CITY OF ALBUQUERQUE

RE: 13704 Ellena Gallegos NE
Grading Plan
Stamp Date: 7/18/17
Hydrology File: E24D002A

13704 ELENA GALLEGOS	DRAWN BY WCVJ
	GRADING AND DRAINAGE PLAN	DATE 7-16-17
7/18/17 8/8/17		21740-LAYOUT-5-28-17
DAVID SOULE P.E. #14522		SHEET #
		JOB # 21740

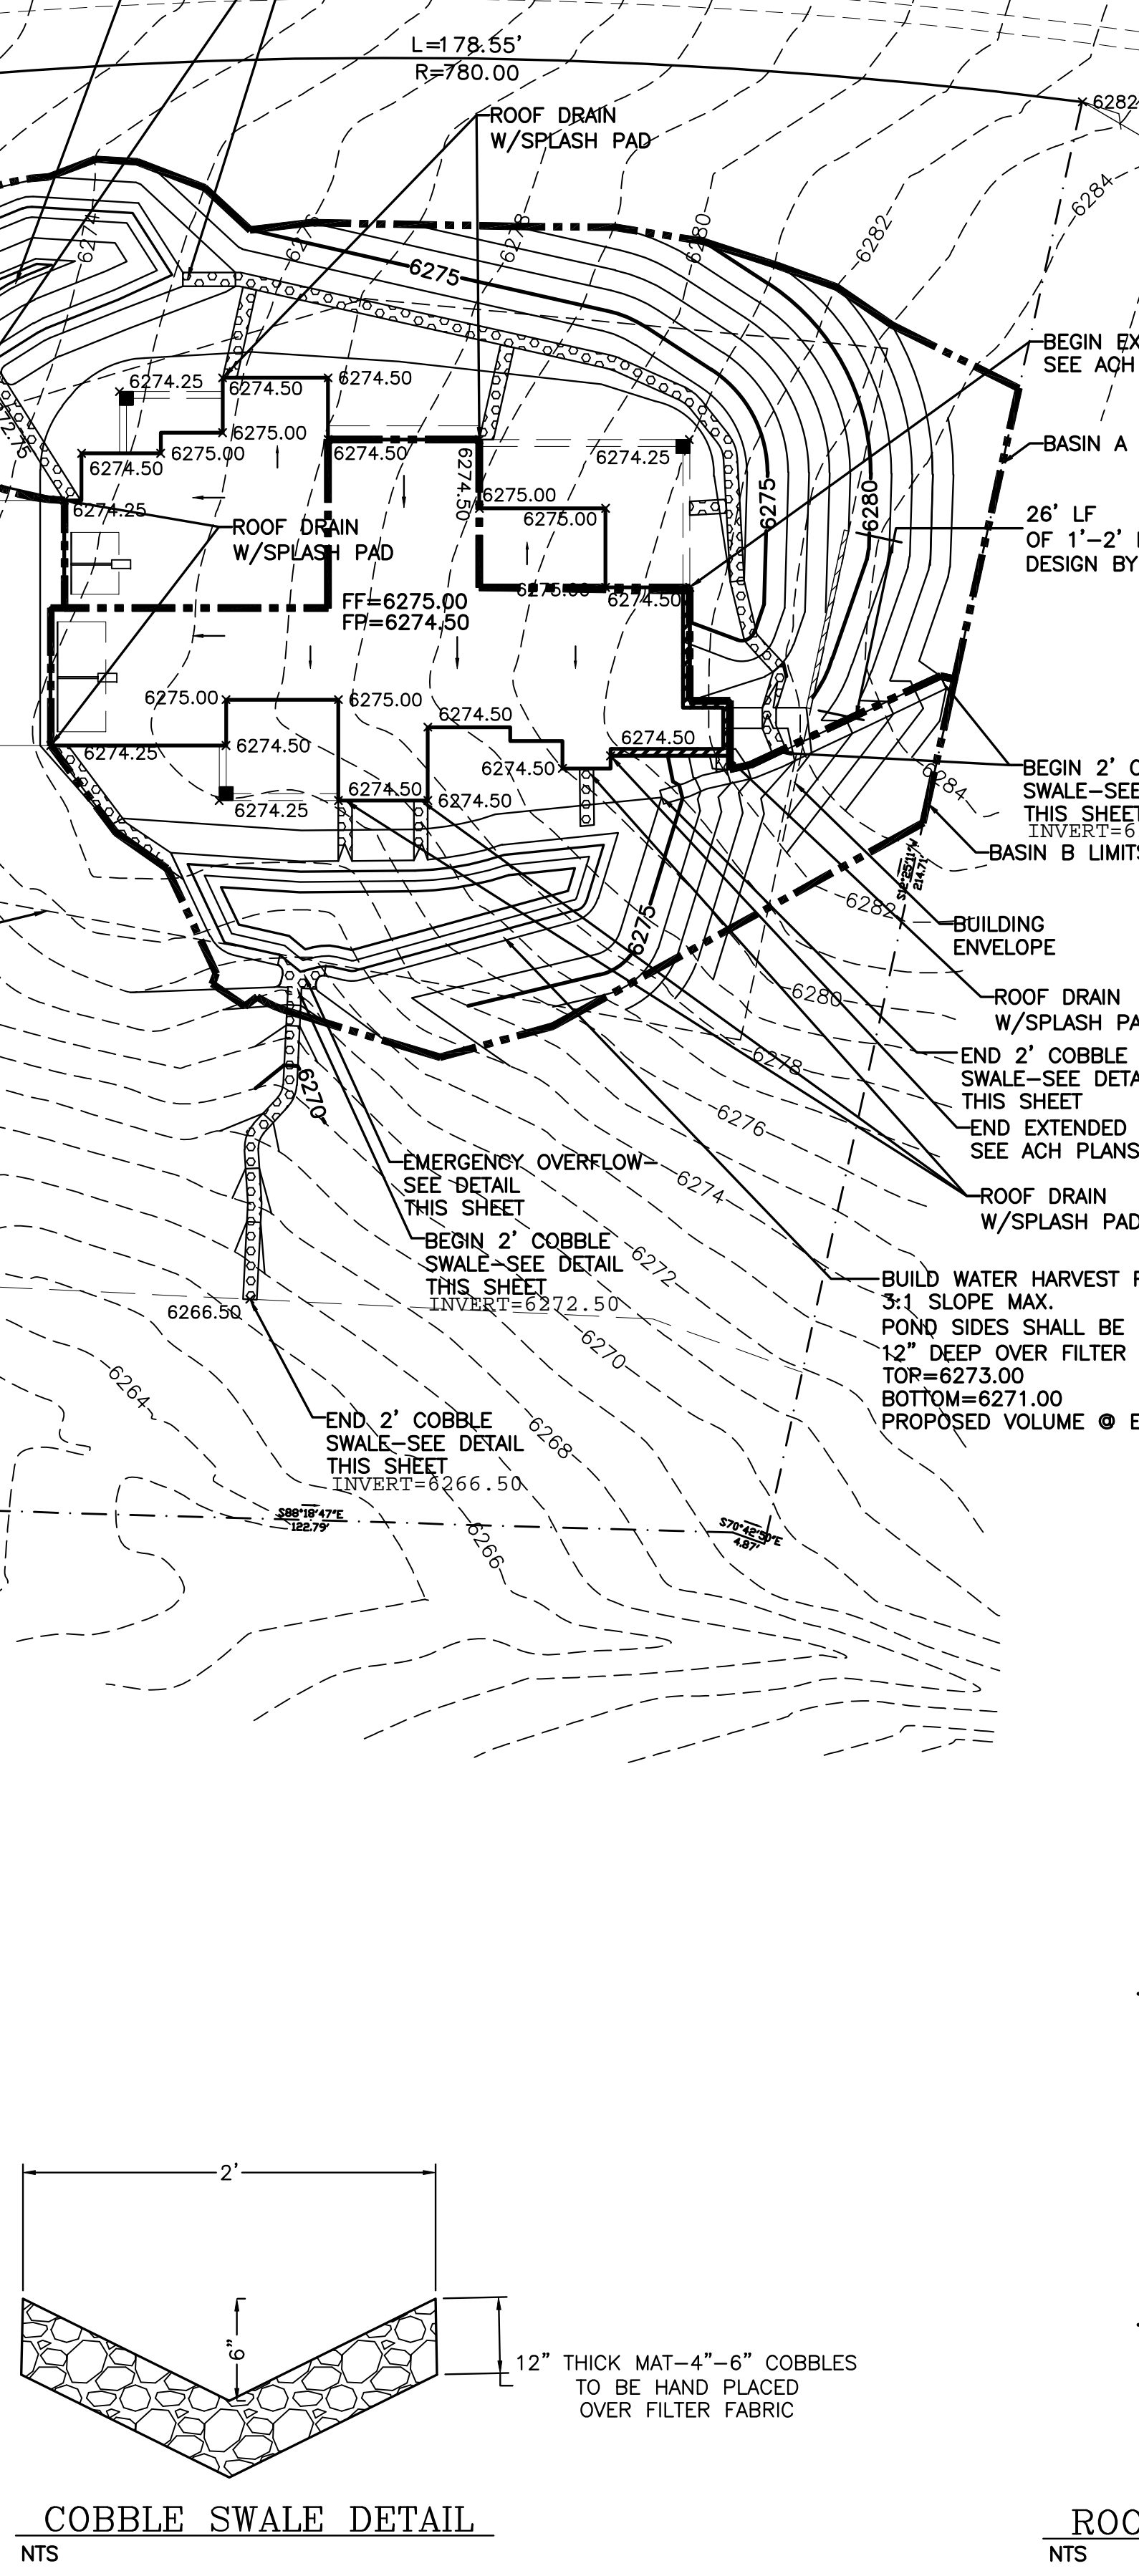
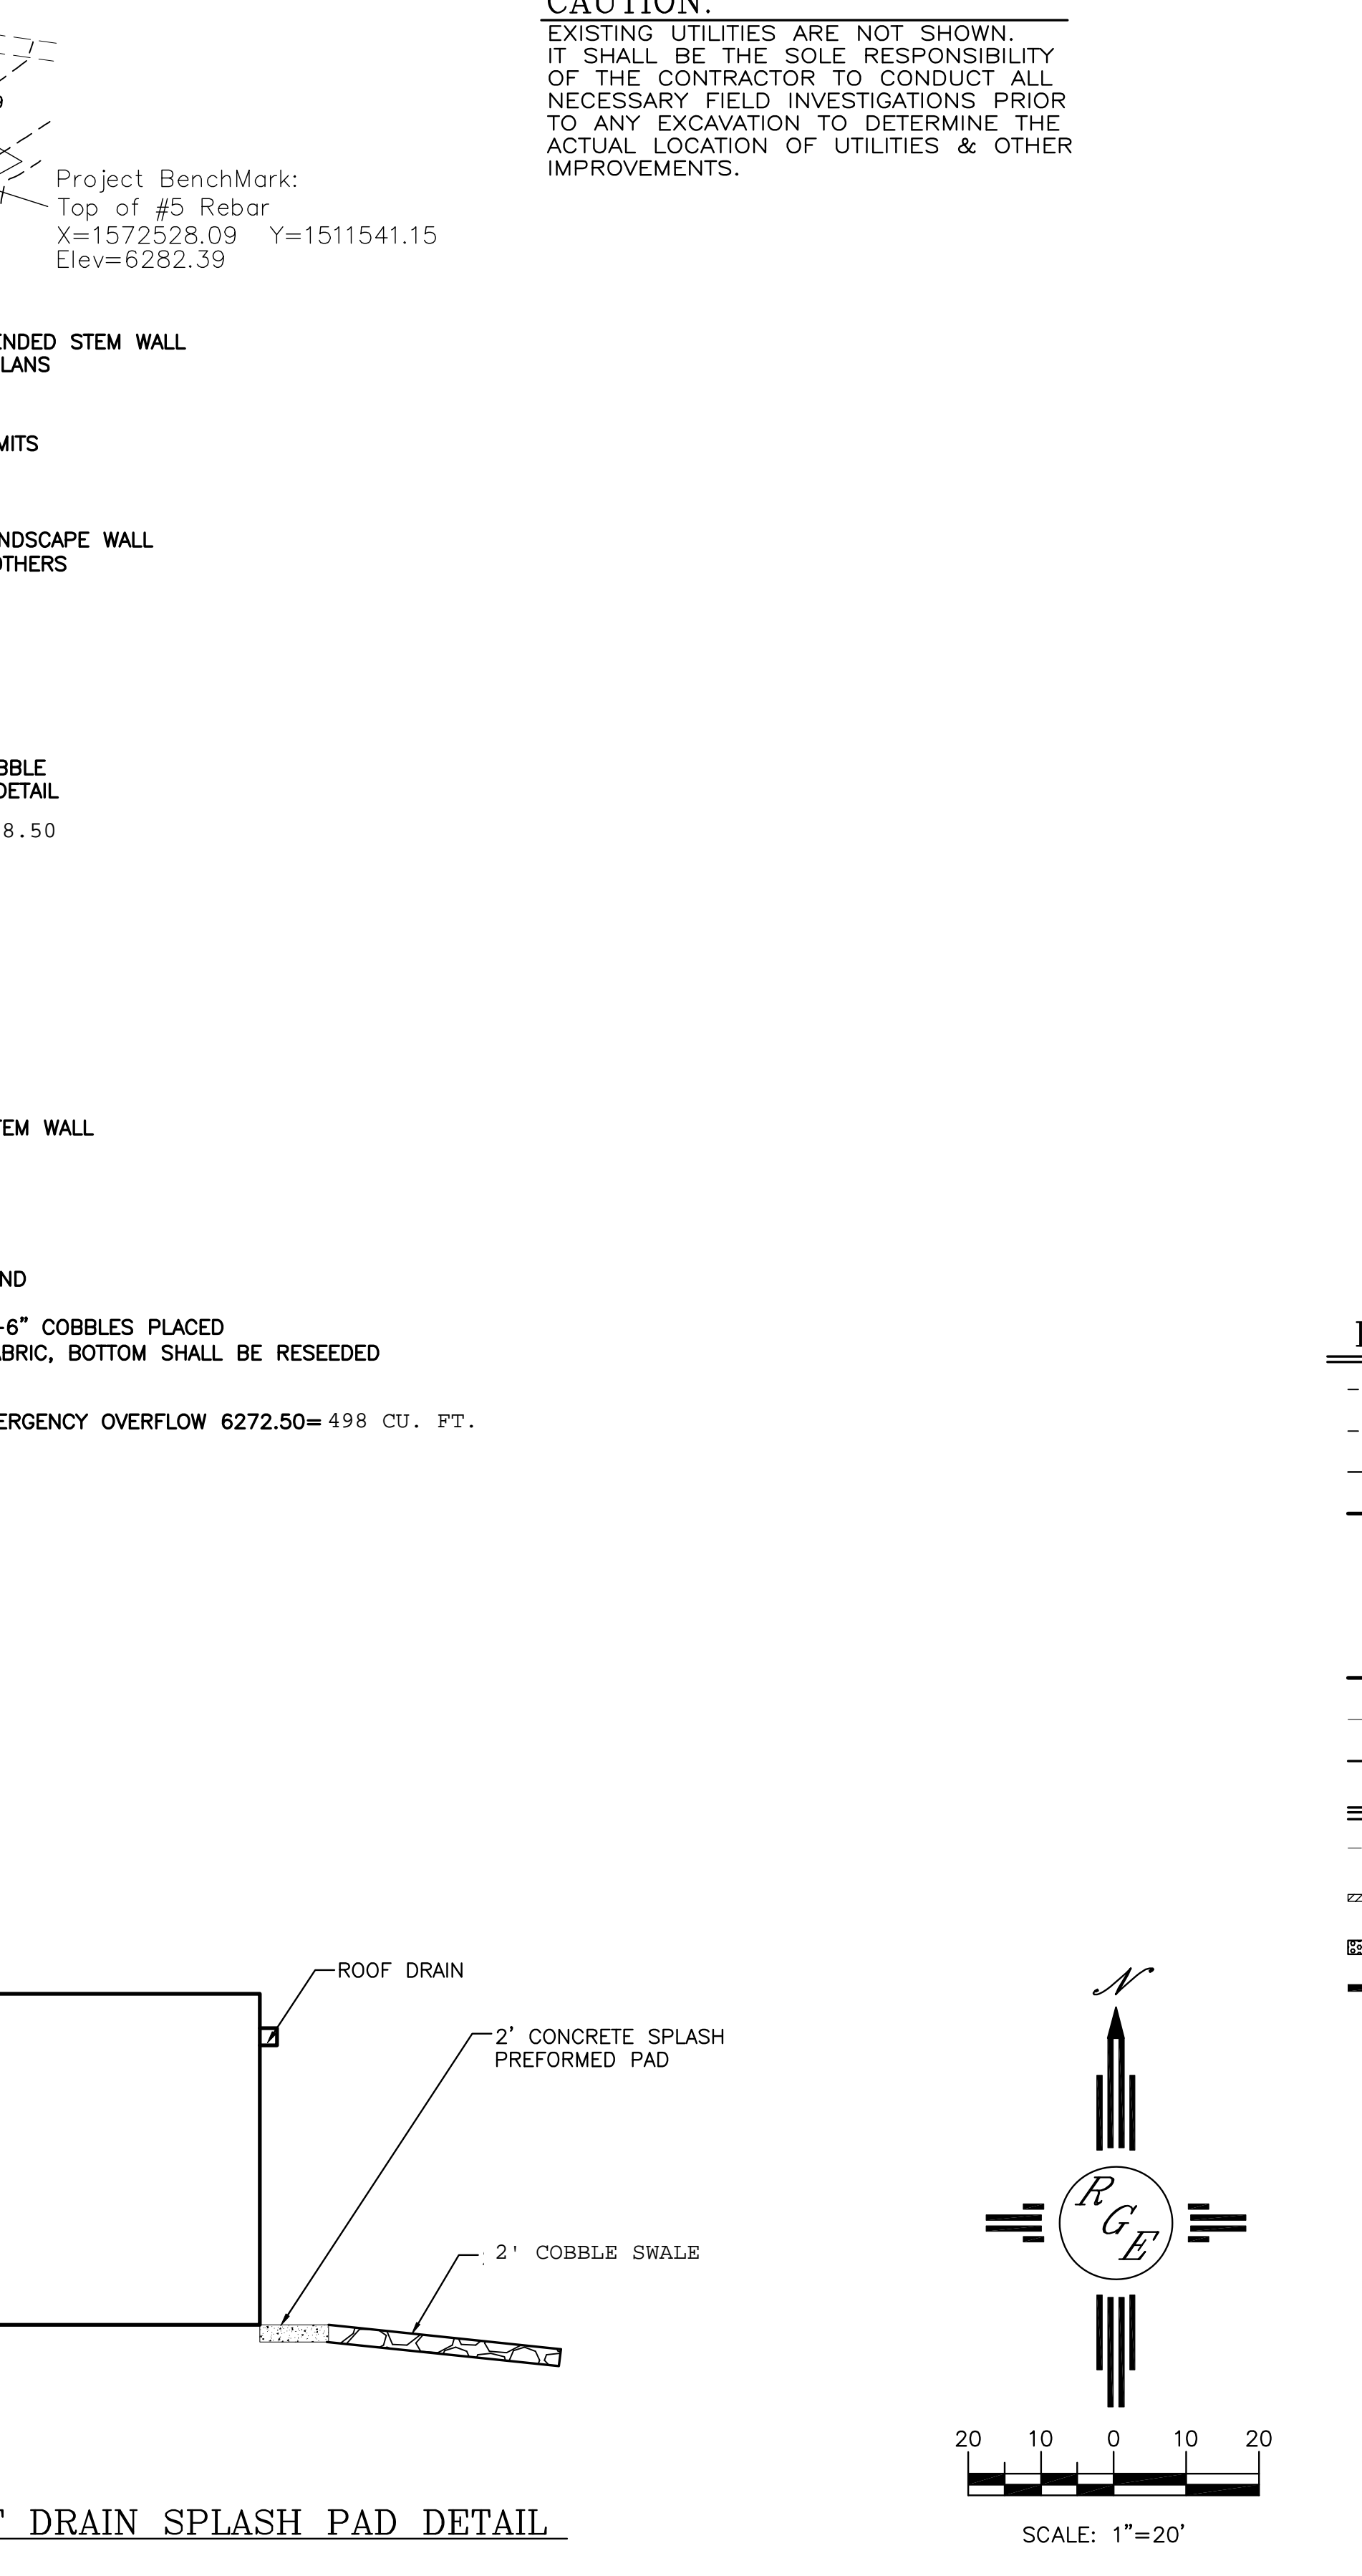
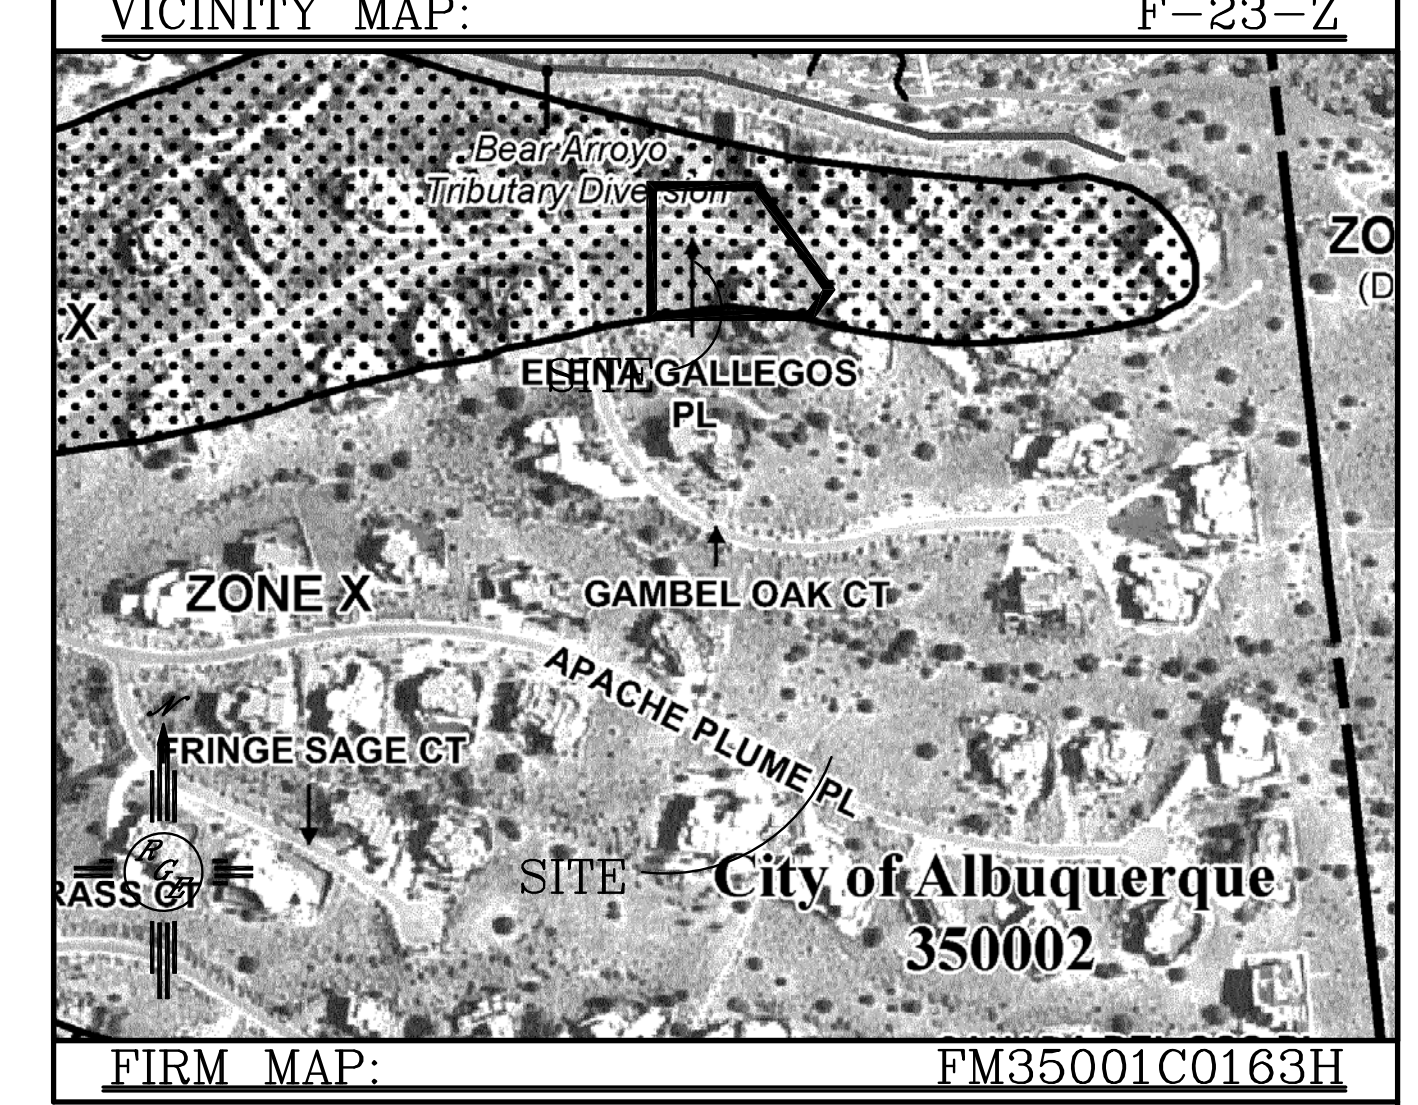
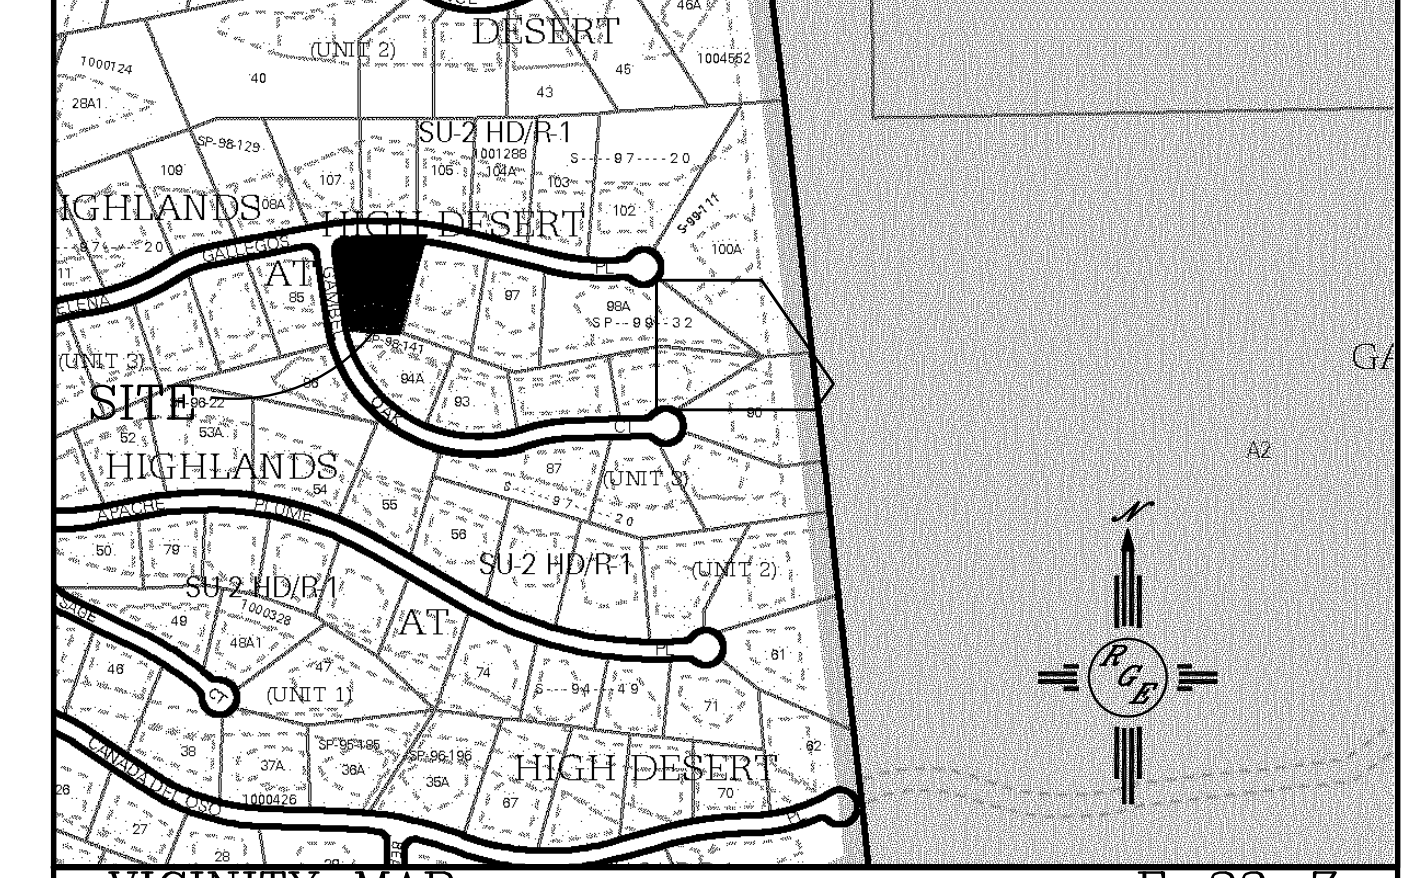
1. Please provide both the beginning and ending flowlines for all the cobble swales.
2. Please add the weir calculations for the emergency overflows.
3. There is enough room on the sheet, so please enlarge the Site Hydrology calculations and notes.
